## **Great North Road Solar and Biodiversity Park**

S51 and S55 Responses Cover Letter

Document Reference – EN010162/APP/1.1A

**Application by Elements Green Trent Limited: Great North Road Solar and Biodiversity Park (Application Reference: EN010162)**

Rev:
Rev01

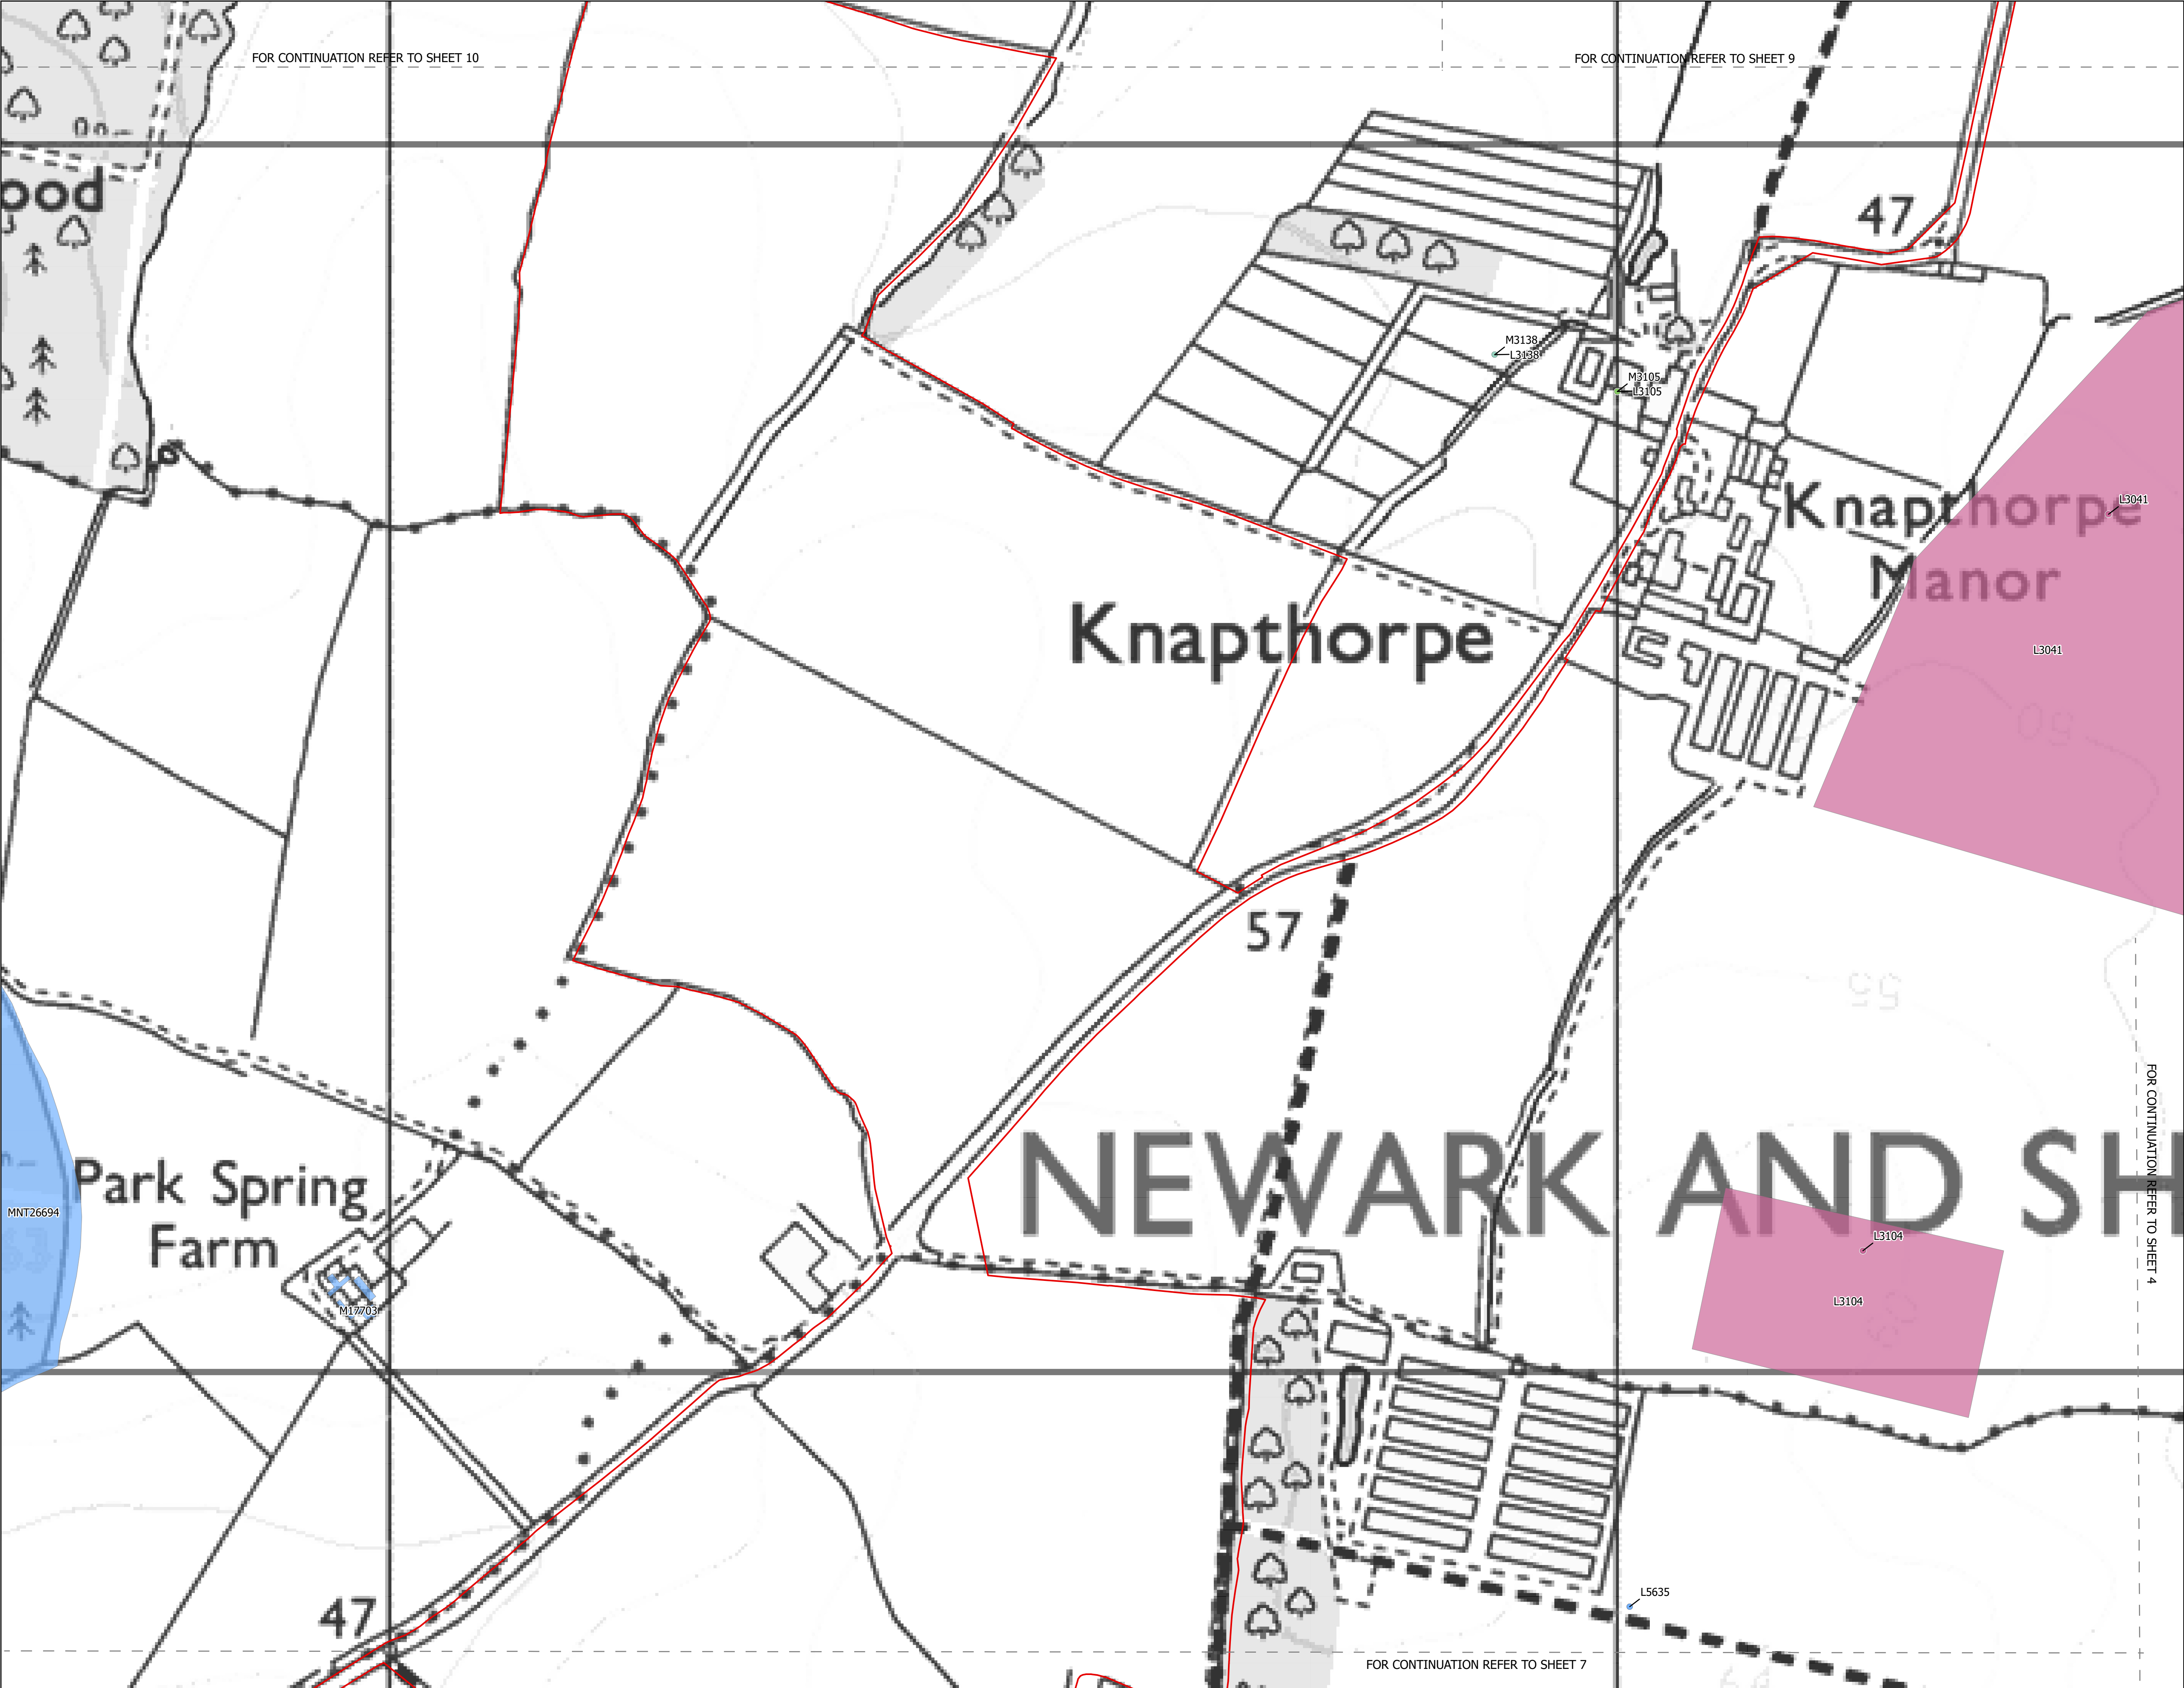
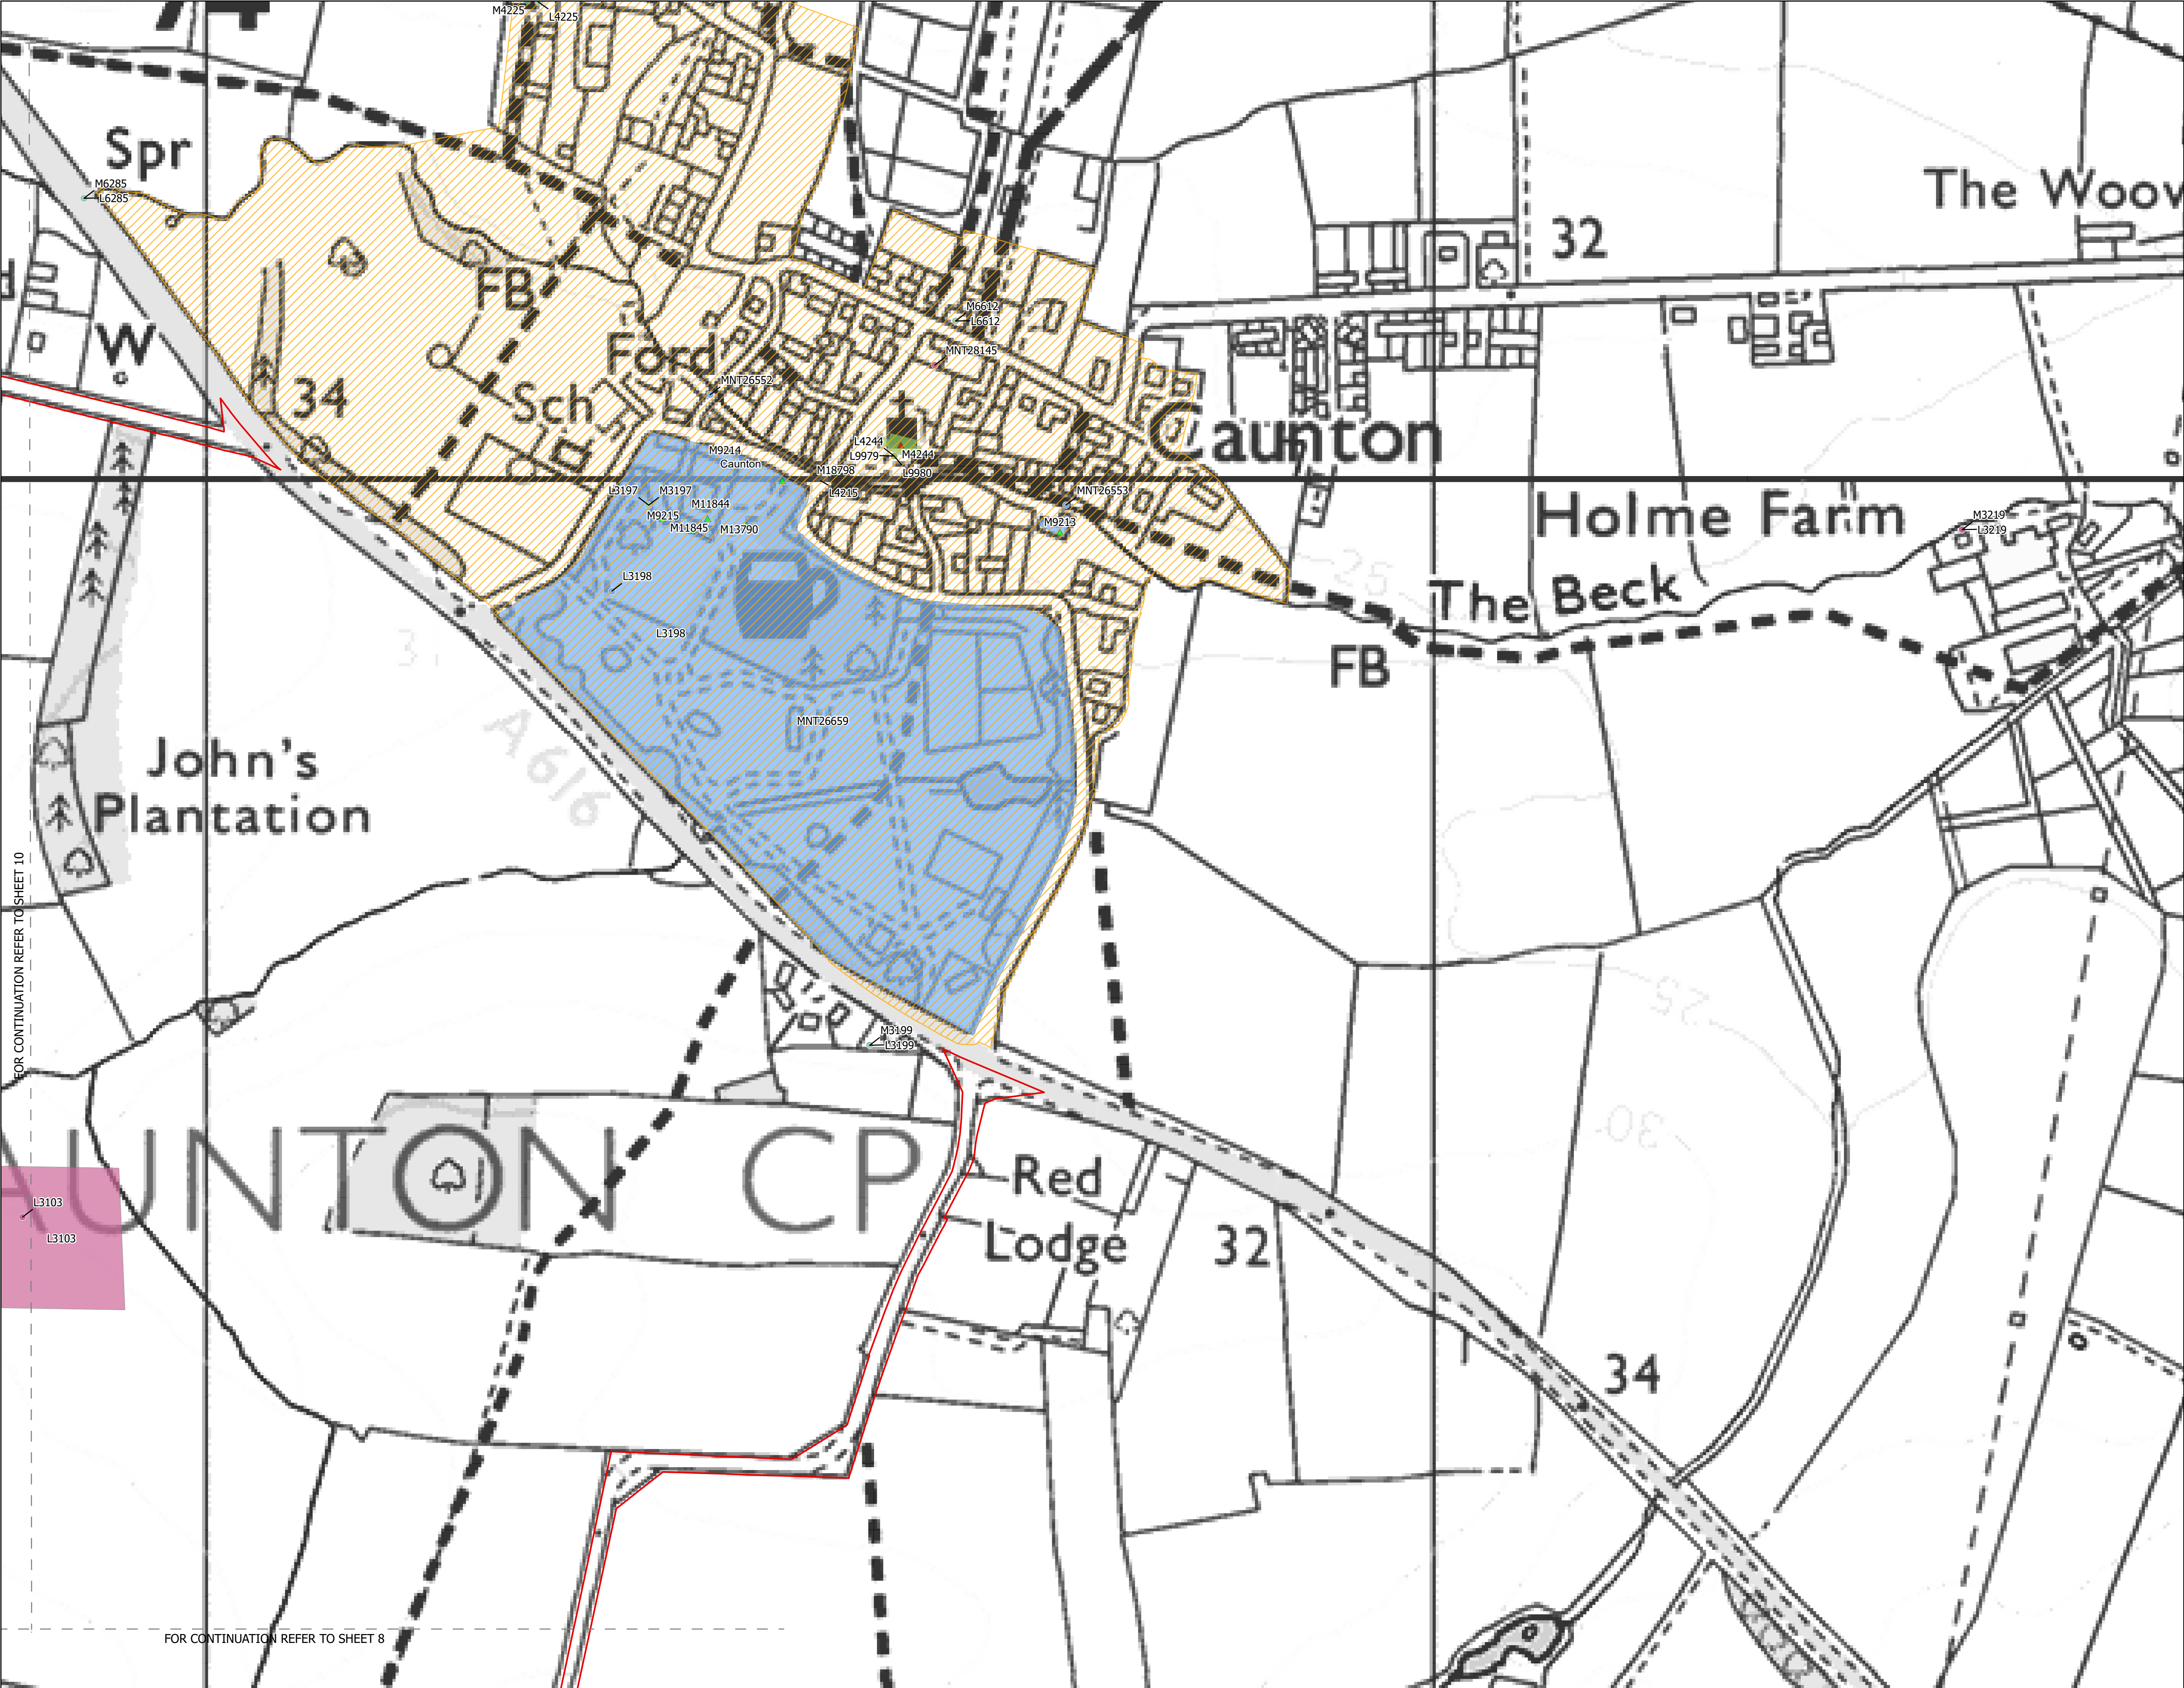
The applicant is advised to review these figures for clarity, specifically relating to the following points:

- due to the scale of the icons used and similar colouring, it is difficult to differentiate between Historic Environment Record (HER) assets and listed buildings/ grades
- a very similar colouring scheme between HER recorded 'undated' period and scheduled monuments keys has been used
- due to the small scale of the icons, the labelling sometimes obscures the record being shown.

An updated **Statutory and non-statutory features of Historic Environment Plan [EN010162/APP/2.15A]** has been submitted. The icons used on the plans have been updated to be clearer, along with a clearer differentiation between the colours used, and a clearer basemap.
